MONUMENT FIRE DISTRICT
16055 Old Forest Point, Suite #102
Monument, CO 80132
(719) 484-0911
www.monumentfire.org
Proudly serving the Tri-Lakes Region

To: El Paso County Planning and Community Development Department
From: Jonathan Bradley, Fire Marshal
Subject: Iron Ridge-Colt Court
Date: October 23, 2025

The Monument Fire District has reviewed the project and were asked the specific question: Does the extension of Colt Court meet fire department requirements.

FINAL PLAT
IRON RIDGE FILING NO. 2

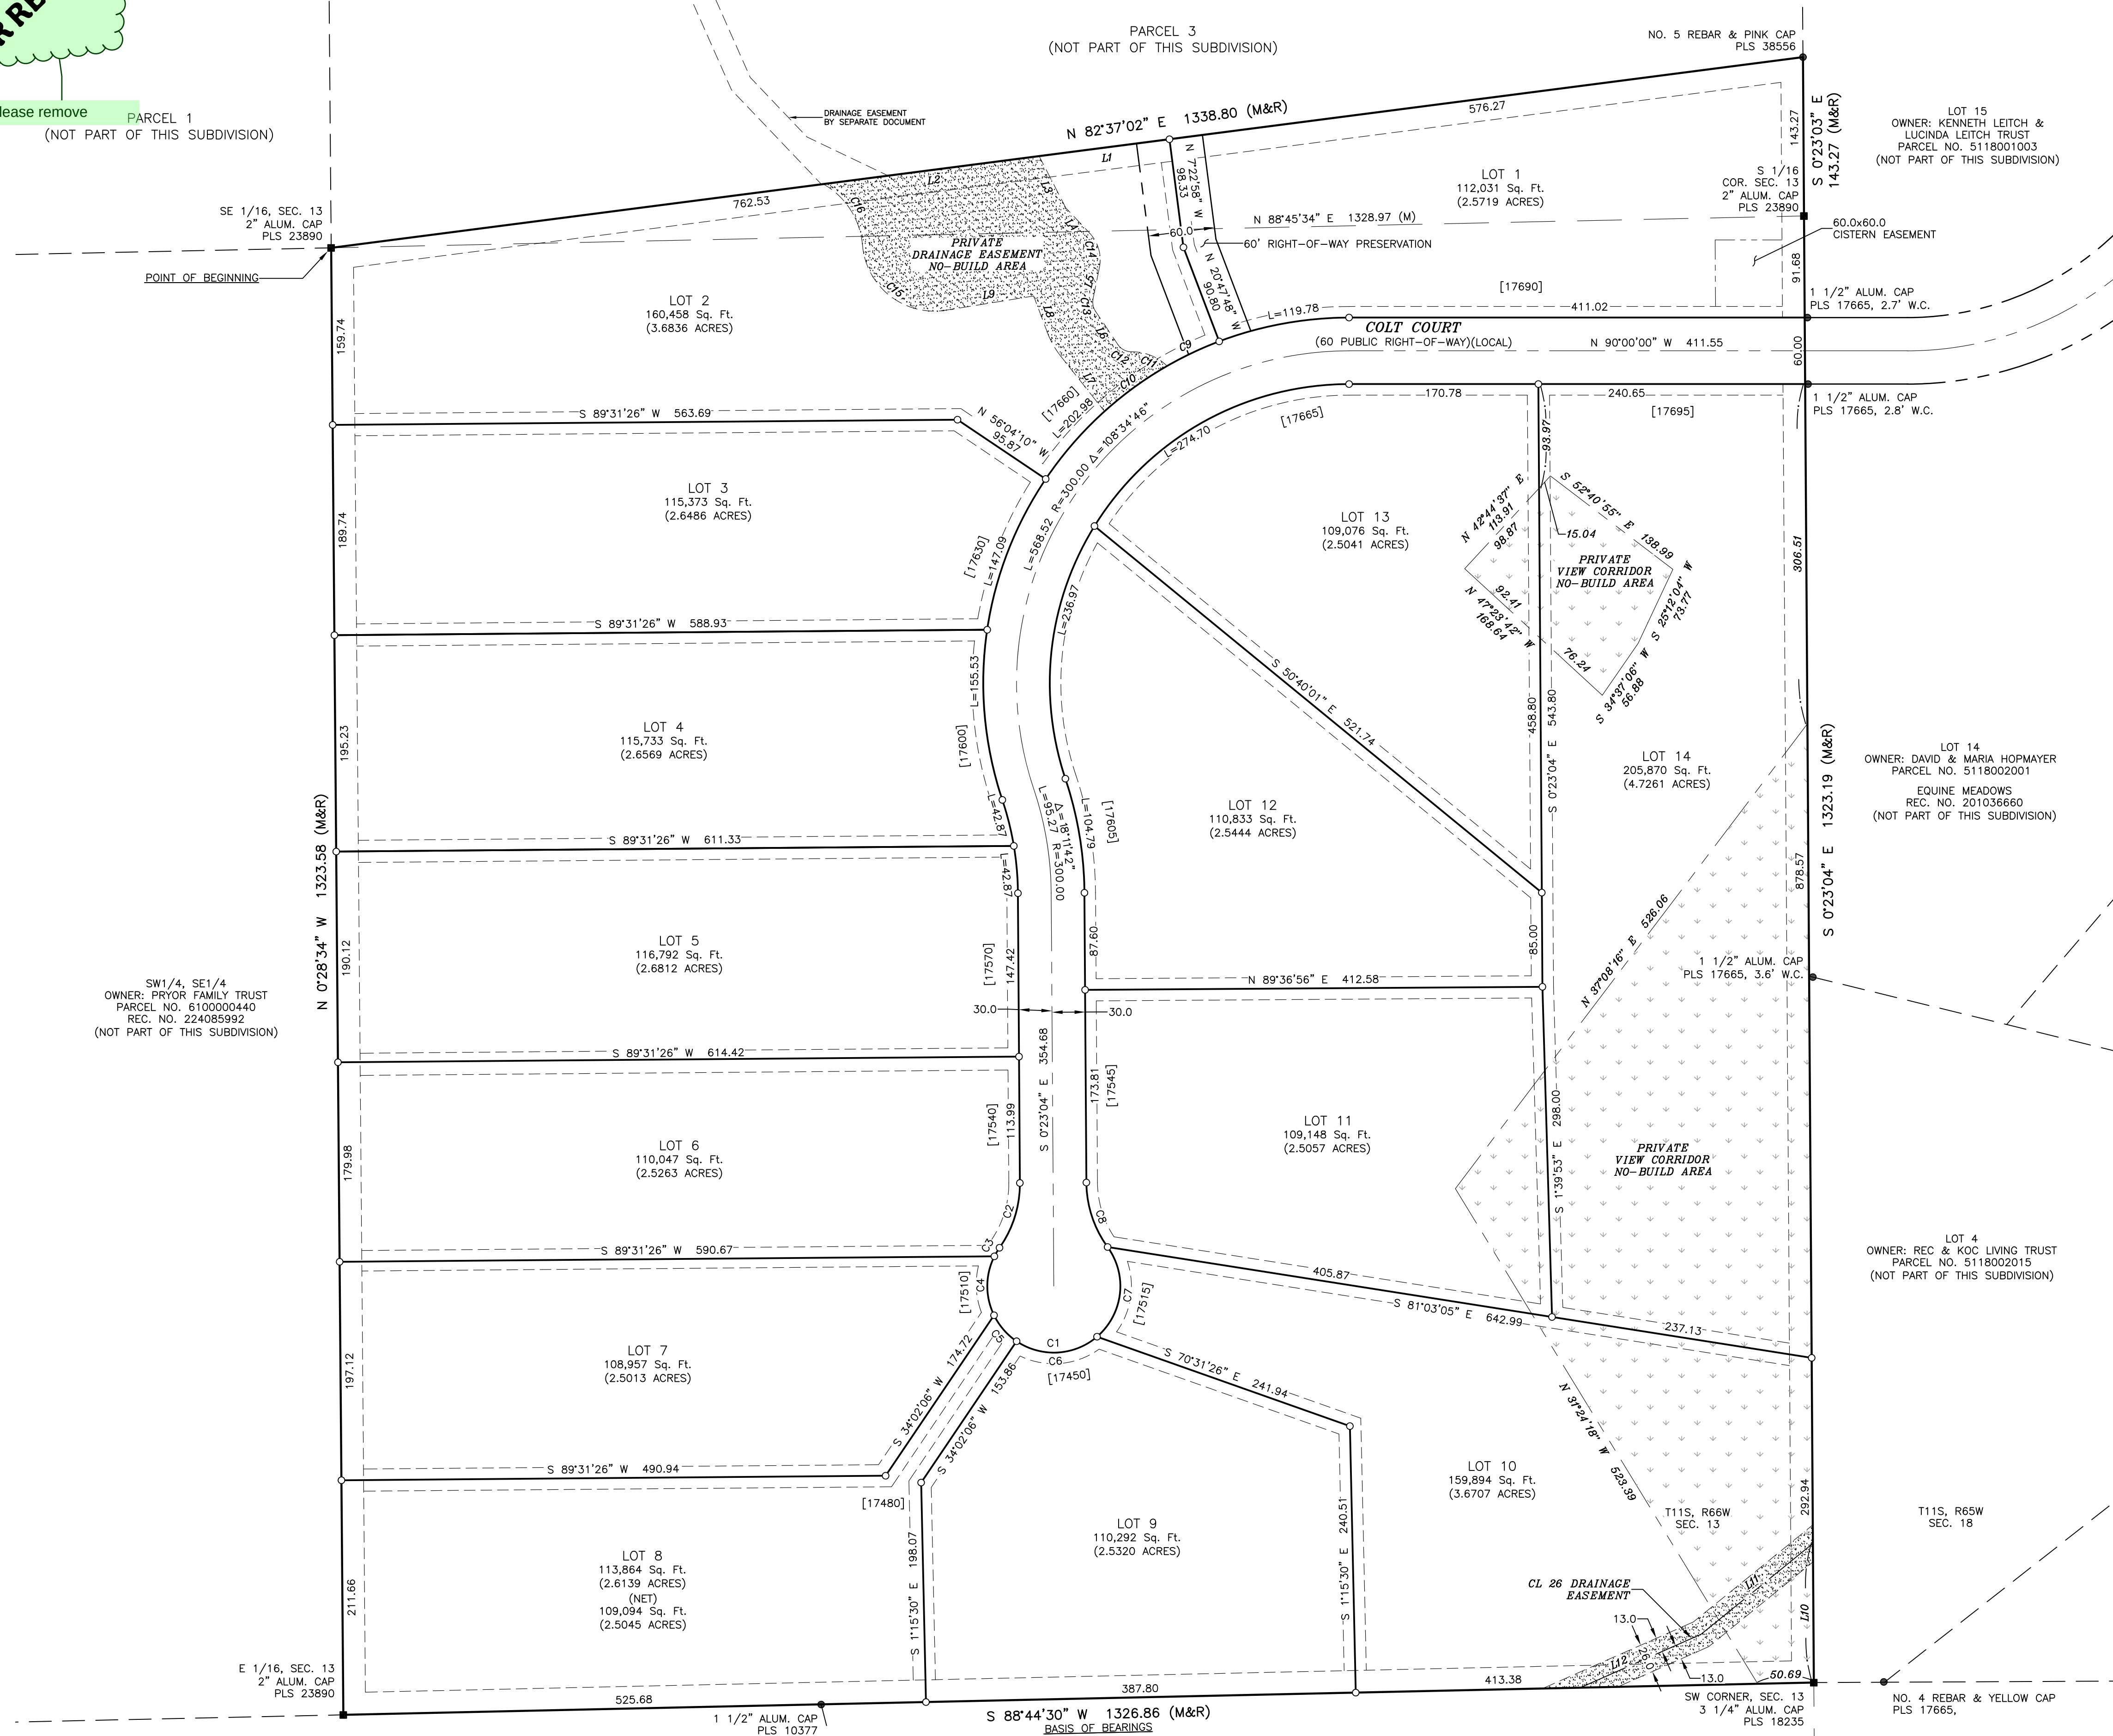
- The Colt Court extension is approximately 1500' long (individual property driveways may be considered to meet intermediate turnaround requirements)
- The Colt Court driving surface is 60' wide
- The Colt Court cul-du-sac has 120' diameter

These dimensions are acceptable to the District.
